***Planning Department
Transportation Development Services***

**Re: Central & Atrisco Façade Remodel, 4010 Central Ave. SW
Traffic Circulation Layout**
Architect's Stamp dated 05-07-14 (K12-D033)

Based upon the information provided in your submittal received 07-17-14, the above referenced plan cannot be approved for Building Permit until the following comments are addressed:

TRAFFIC CIRCULATION LAYOUT

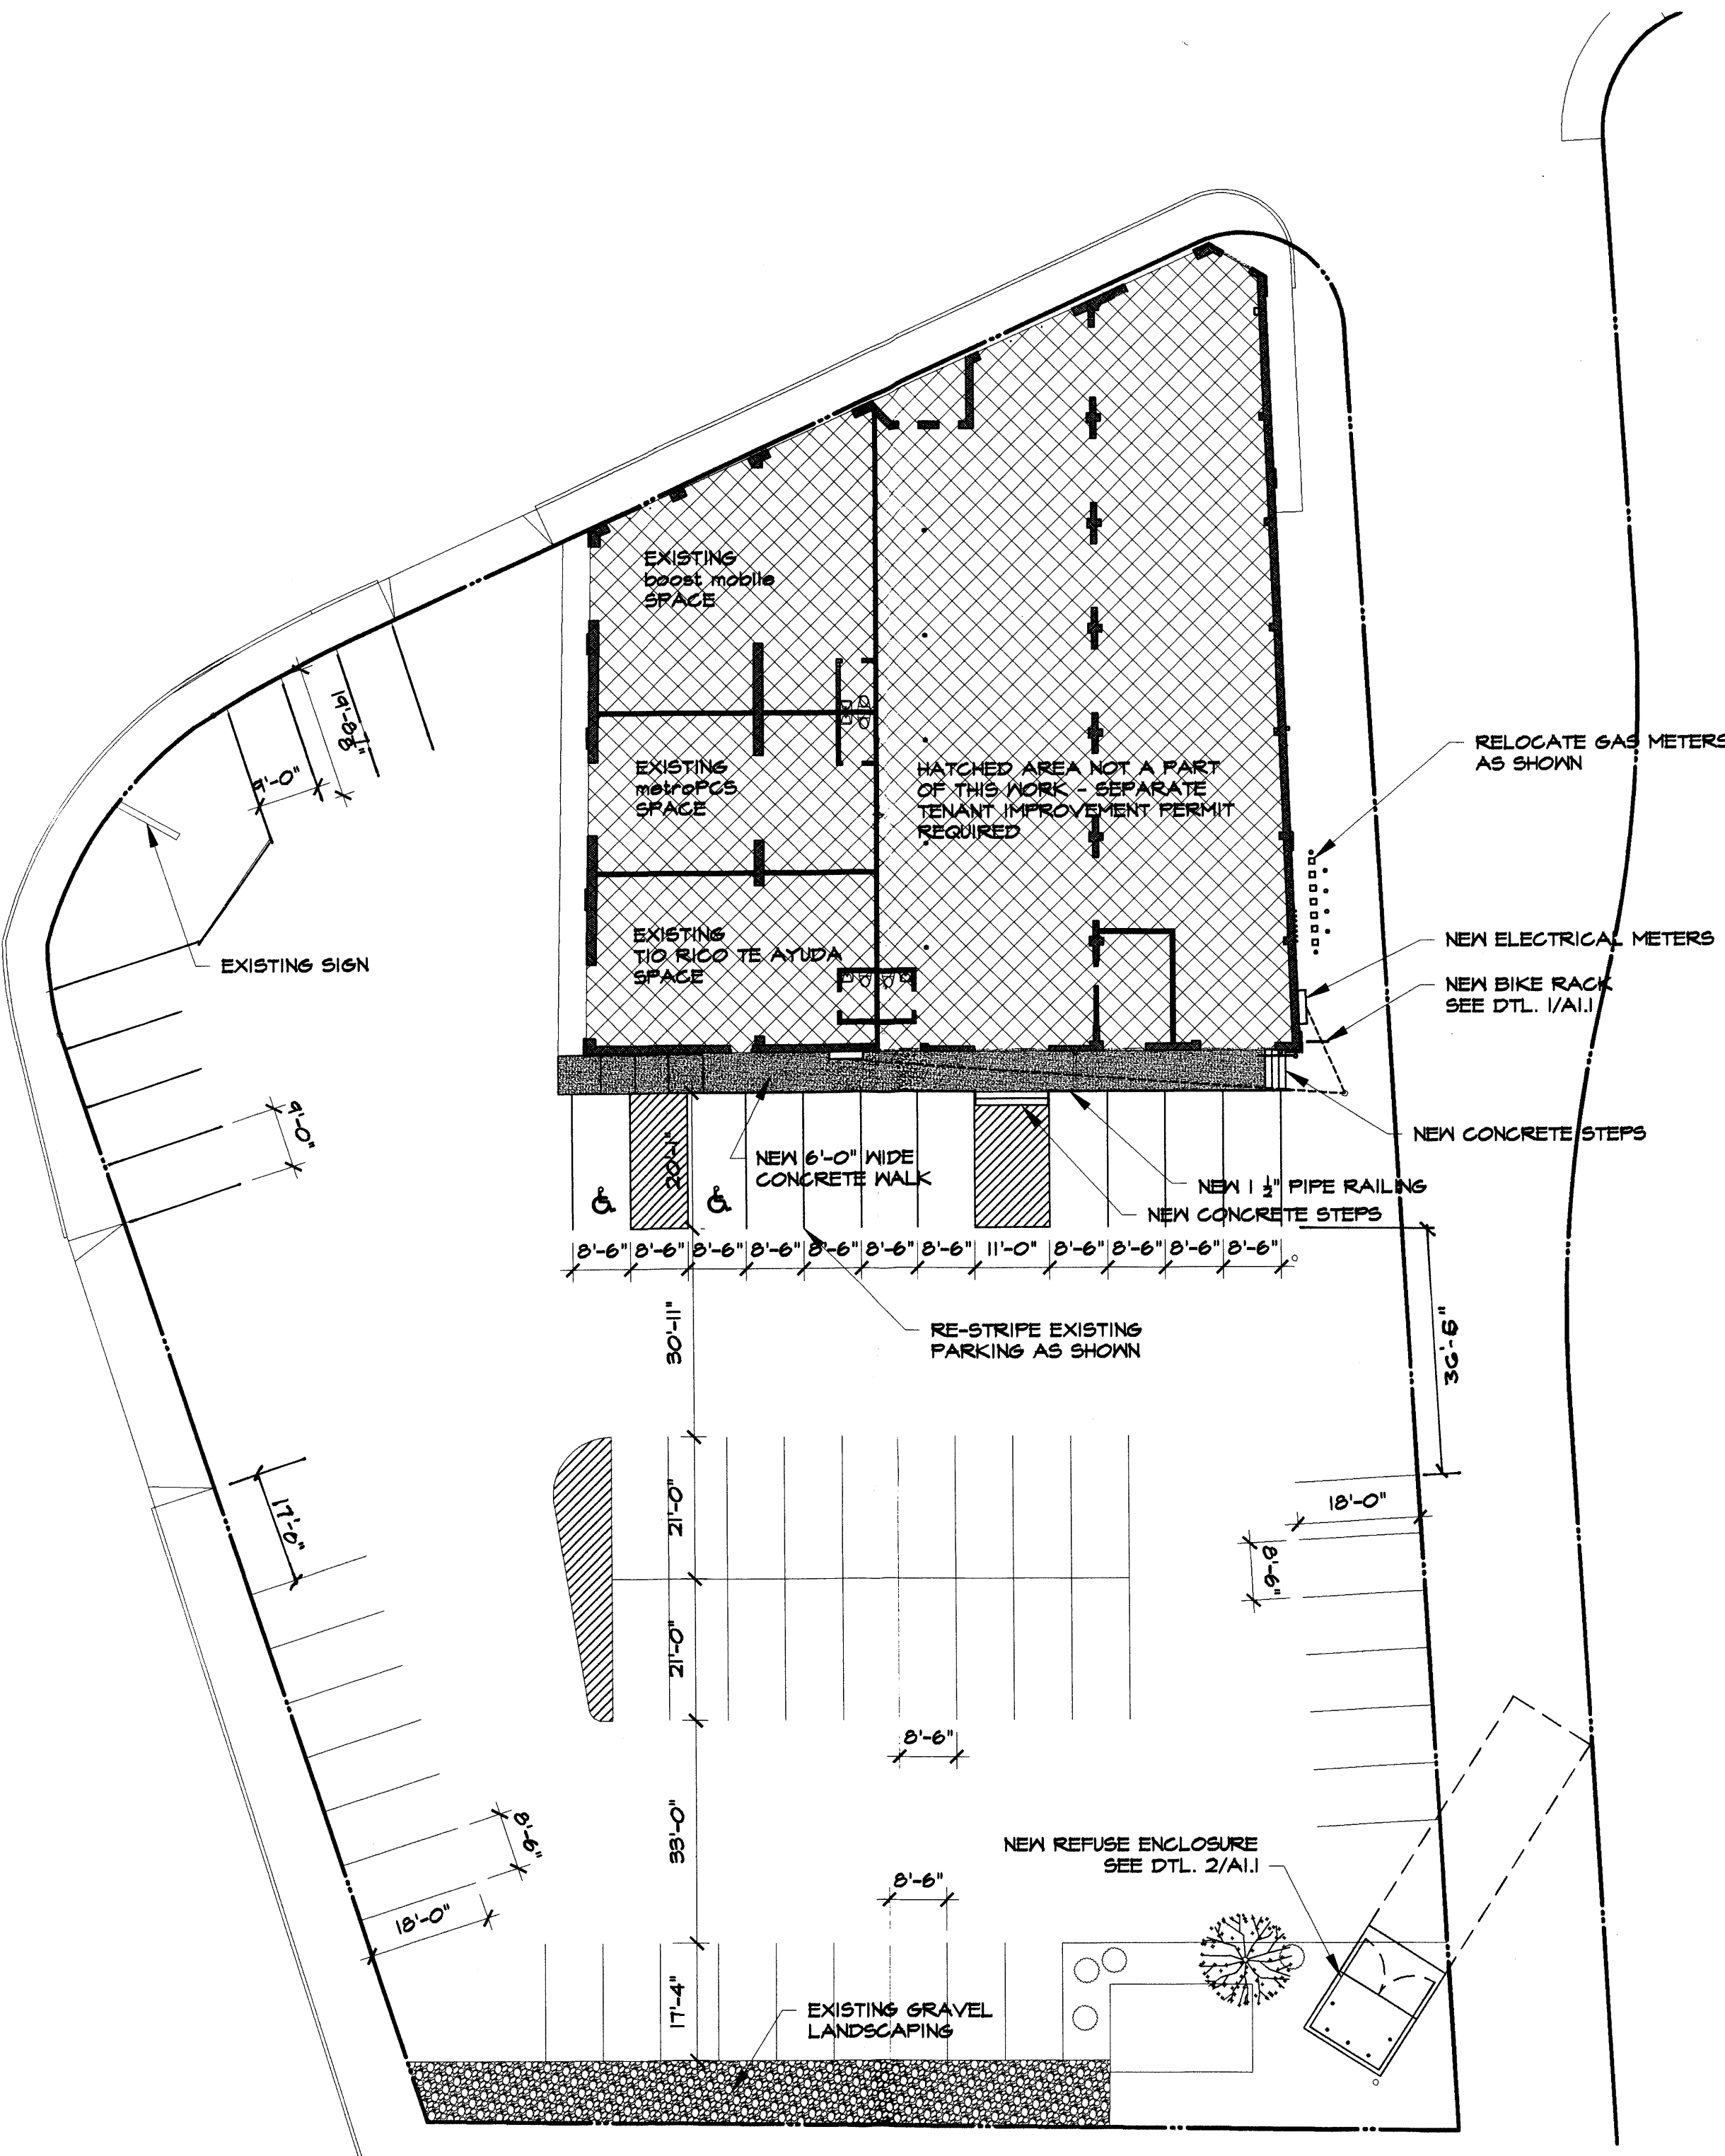
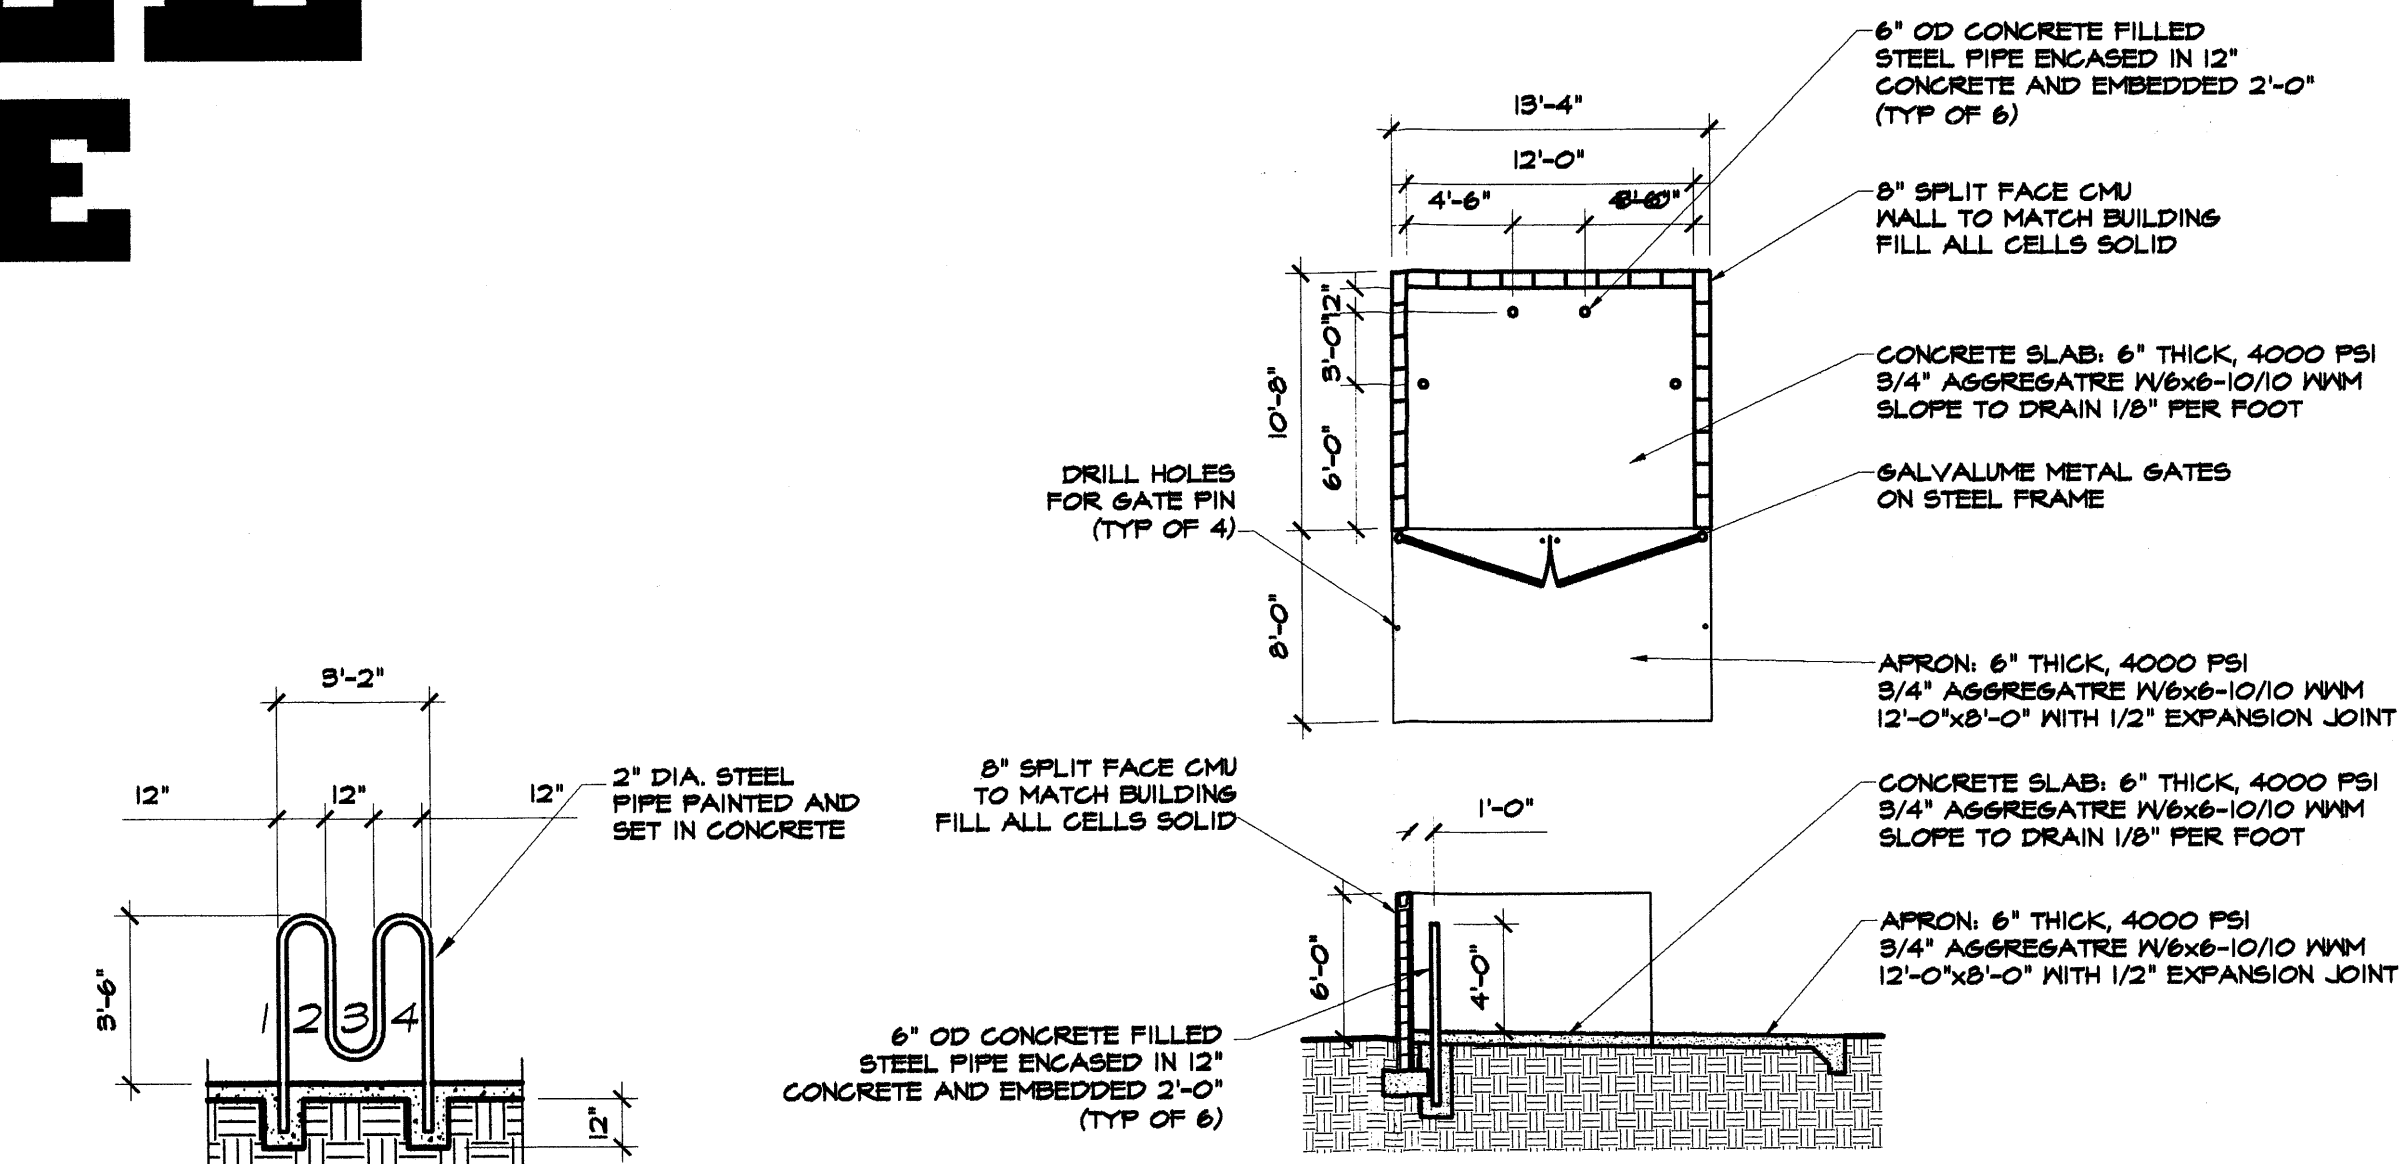
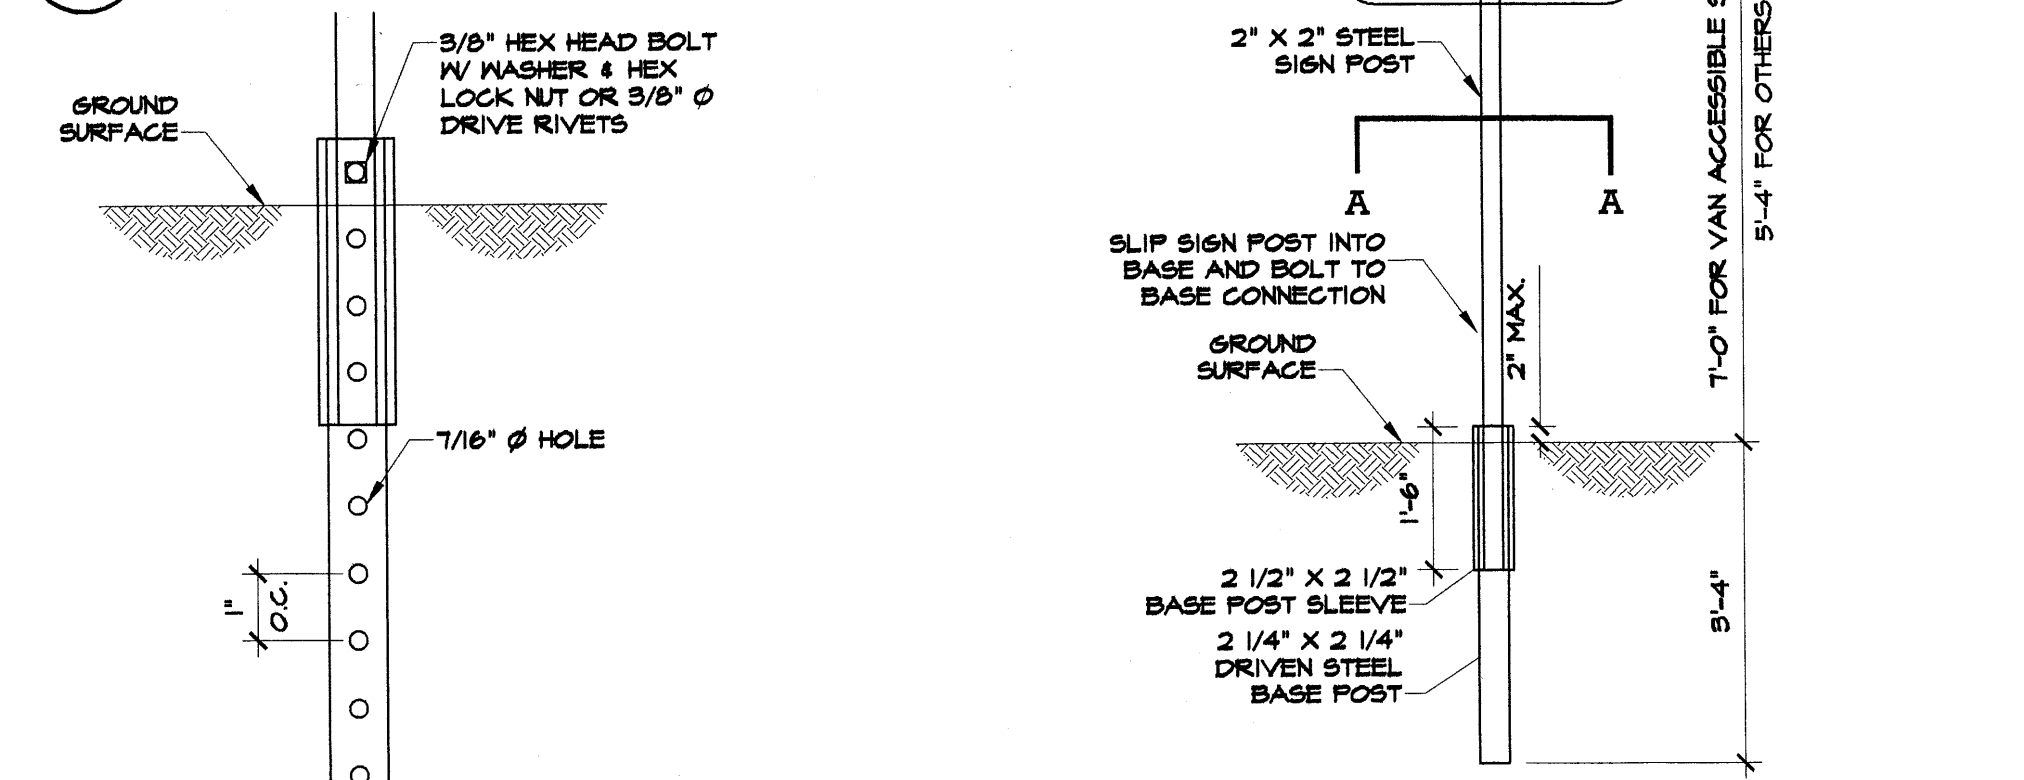
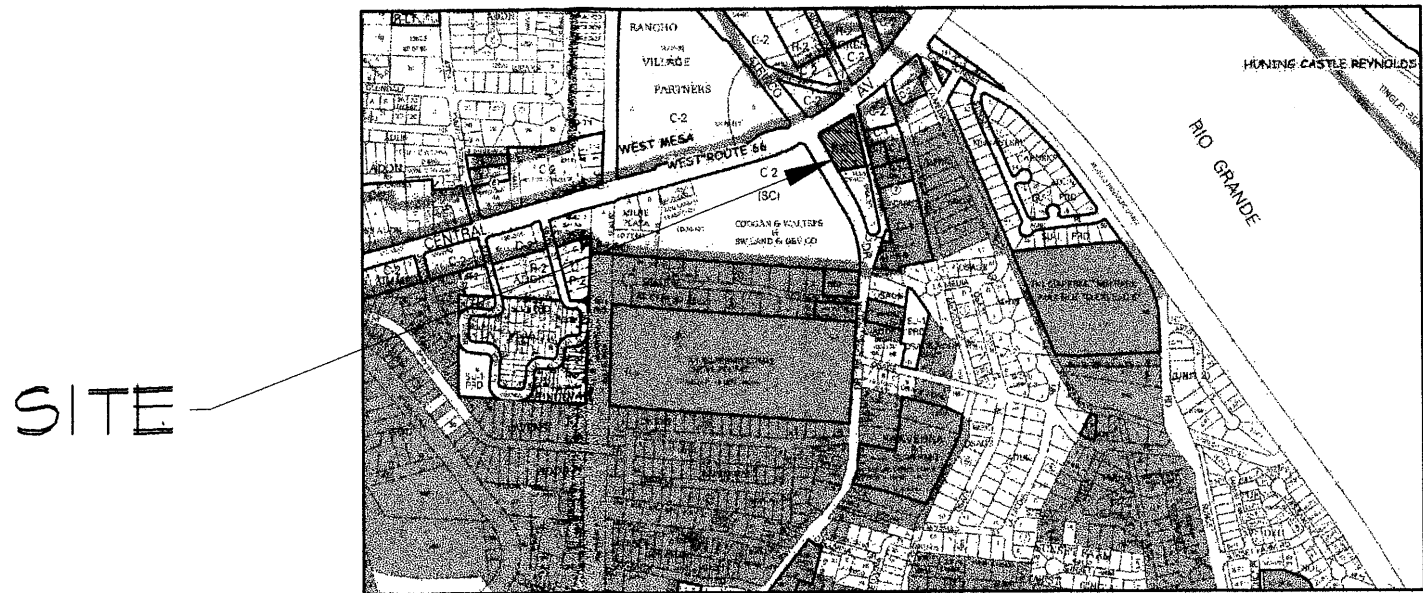
- PO Box 1293
Albuquerque
New Mexico 87103
www.cabq.gov
1. NMBC Table 1106.1 requires 4 ADA accessible parking spaces one of which needs to be Van accessible.

2. Please identify all existing buildings, doors, structures, sidewalks, curbs, drive pads, walls and anything that influences the parking and circulation on the site.

3. Identify the right of way width, medians, curb cuts, and street widths on both sides of the street.
 4. Please list the width and length for all parking spaces.

5. Parking spaces cannot cross over the lot lines.
 6. The ADA accessible parking sign must have the required language per 66-7-352.4C NMSA 1978 **"Violators Are Subject to a Fine and/or Towing."**

7. The ADA access aisle shall have the words **"NO PARKING"** in capital letters, each of which shall be at least one foot high and at least two inches wide, placed at the rear of the parking space so as to be close to where an adjacent vehicle's rear tire would be placed. (66-1-4.1.B NMSA 1978)

8. Show all drive aisle widths and radii.
 9. List radii for all curves shown; for passenger vehicles, the minimum end island radius is 15 feet. Landscape island radius for delivery trucks, fire trucks, etc. is 25 feet or larger

10. Per the DPM, a 6 ft. wide ADA accessible pedestrian pathway is required from the public sidewalk to the building entrances. Please clearly show this pathway and provide details.

11. All sidewalks along streets should be placed at the property line.
12. Provide a min 6" or max 8" high concrete barrier curb or other acceptable barrier between landscaping and parking areas and/or drive aisles.

13. Design delivery vehicle route needs to be shown.
14. Service vehicle and/or refuse vehicle maneuvering must be contained on-site.
15. It is not apparent what type of pavement surface is being proposed. A hard driving surface will be required as part of this proposed project for parking area and drive aisles.

16. Please add the following note to the clear sight triangle: "Landscaping and signage will not interfere with clear sight requirements. Therefore, signs, walls, trees, and shrubbery between 3 and 8 feet tall (as measured from the gutter pan) will not be acceptable in this area."

17. Please specify the City Standard Drawing Number when applicable.
18. Work within the public right of way requires a work order with DRC approved plans.

19. Unused curb cuts must be replaced with sidewalk and curb & gutter. A build note must be provided referring to the appropriate City Standard Drawing.
